Our Ref:AB/120/13/

New householder application forms and validation lists and response to queries on the processing of AB/120/13/

Development Two storey extension to form bedrooms and garage
Location 3C Fitzalan Road Arundel

SITE BLOCK PLAN to scale of 1:500

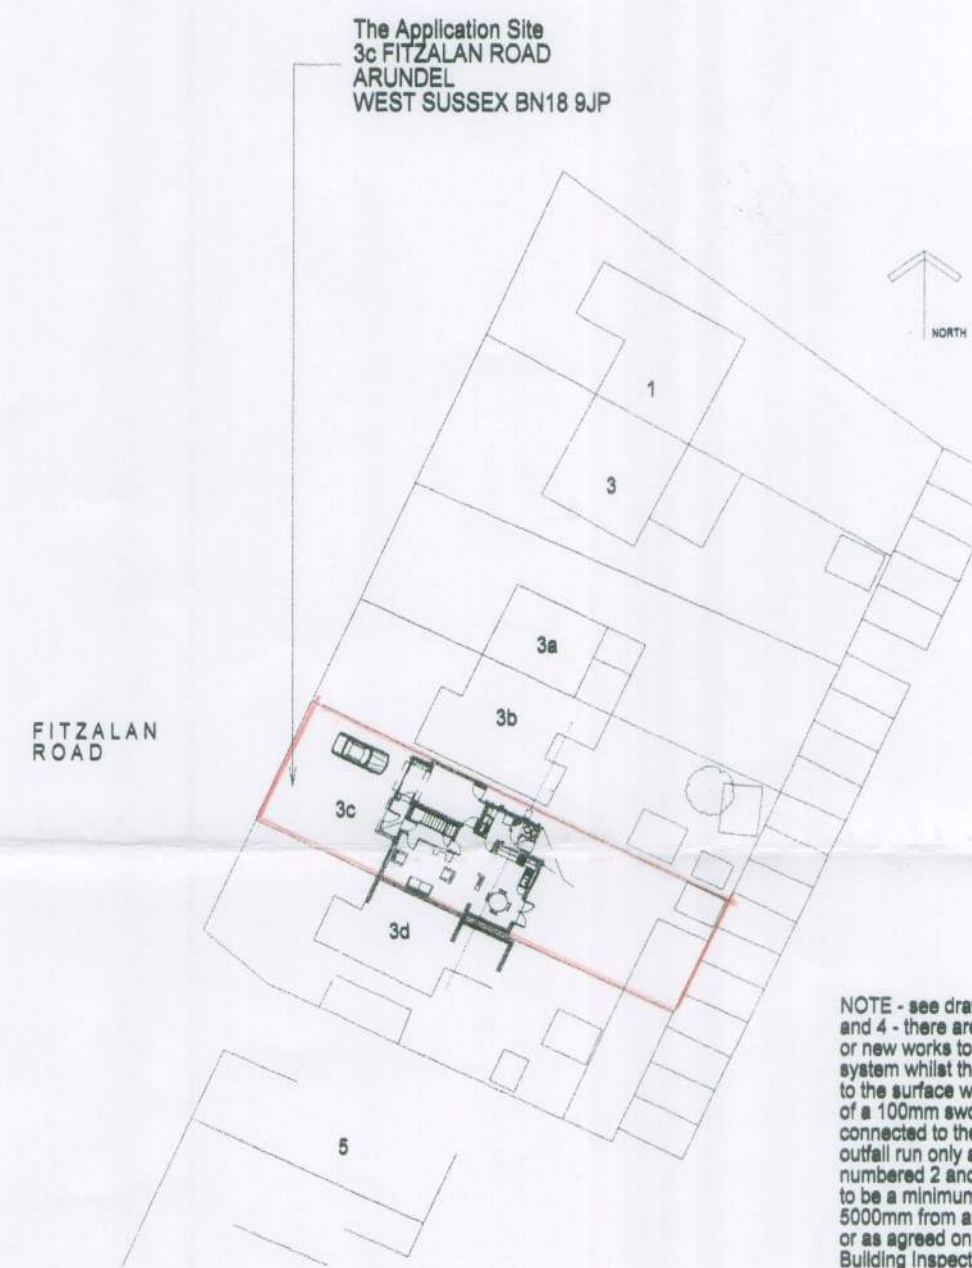
1. Miss Garner did not request that the block plan be highlighted in red, Arun District Council asks for them to be indicated on the plan (hatched, highlighted or as from 1 December clear written dimensions.) We do not request that the boundaries on the block plan are in red. I enclose a copy of her request which asked for them to be clearly highlighted.

2. The dimensions from boundaries are within the national validation requirements list. However from 1 December we have relaxed the requirement and stated that if it is more practical the dimensions can be shown on other plans but that they must be included within the application drawings. We do not require them for porches, dormer windows/roof light proposals. I have highlighted the relevant section on the Householder Requirements lists and in the more general National Validation Requirements list which I have also enclosed.

Please submit 1 electronic or 3 paper copies of an amended block/site plan at a scale of 1:500 or 1:200 to include the proposed extensions clearly highlighted and measurements (in metric) included from the proposed extensions to the boundaries. Further details of what must be included on the plan can be found in the National Validation Requirements.
